Subject: **Geotechnical Update and Review of Plans**  
Proposed Addition to Existing Wai Residence  
7235 East Mercer Way  
Mercer Island, Washington

Reference: *Foundation Considerations and Critical Area Report, Proposed Addition to Existing Wai Residence, 7235 East Mercer Way, Mercer Island, Washington*; Geotech Consultants, Inc.; January 24, 2022.

We were provided with the structural drawings prepared by Consulting Structural Engineering Services, dated 11/6/23 (Sheet S-4). The reconstructed upper floor deck will be supported on isolated pad footings, each of which will be carried on a tripod of 2-inch-diameter pipe piles (Detail P-1/S-4).

P1 Pile Tripod Detail
 1" = 1'-0"

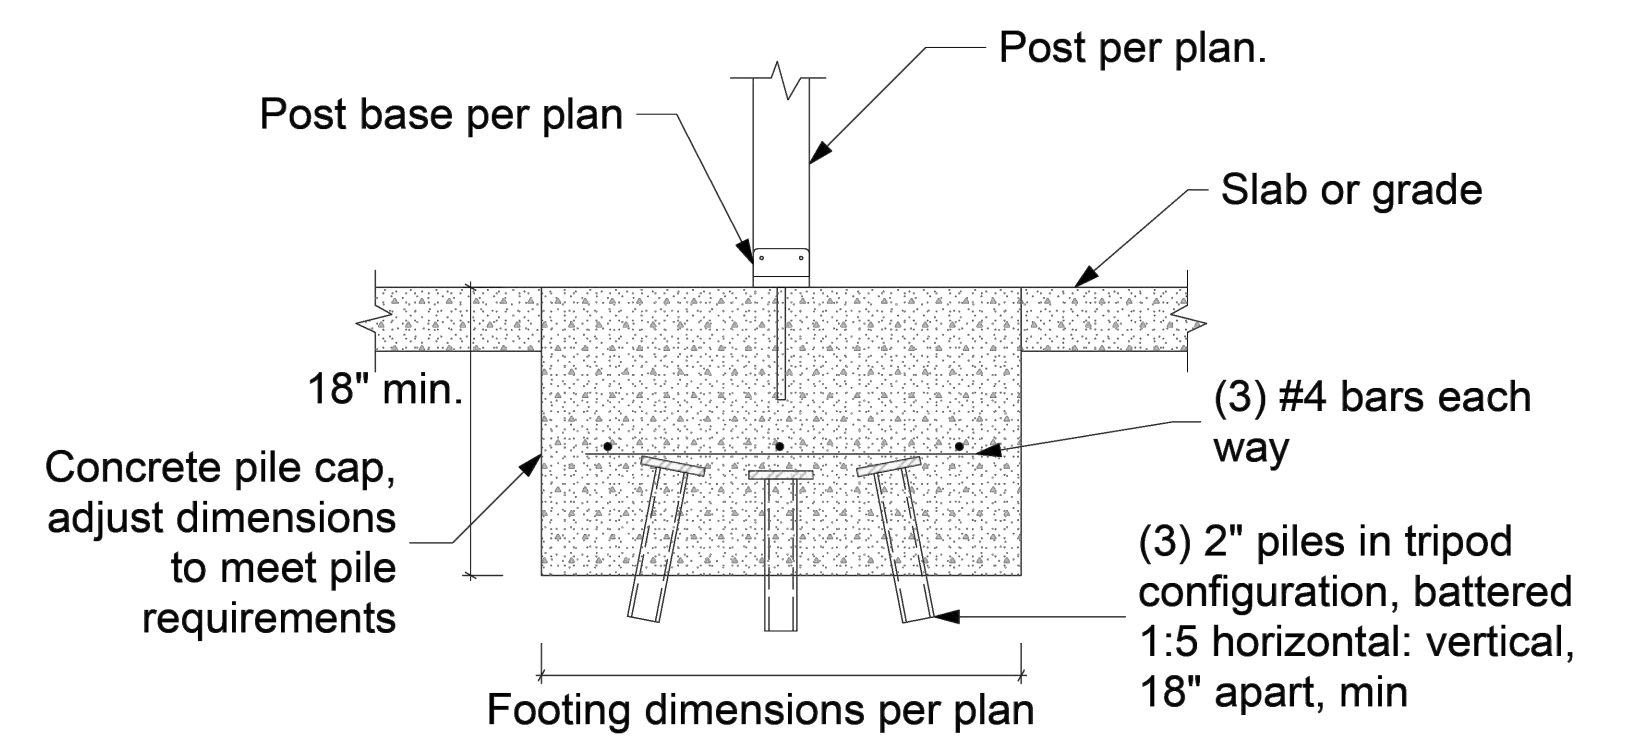
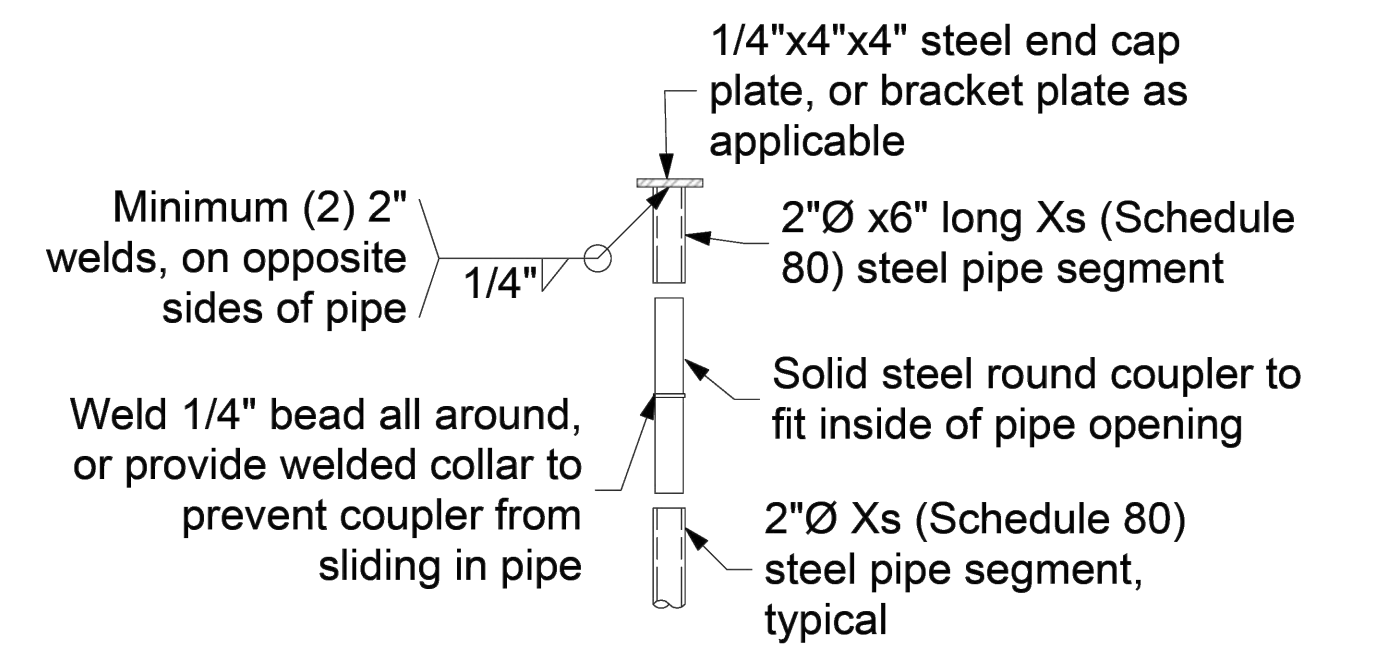
The use of pipe piles to support the new foundations is appropriate, and the plans conform to our recommendations.
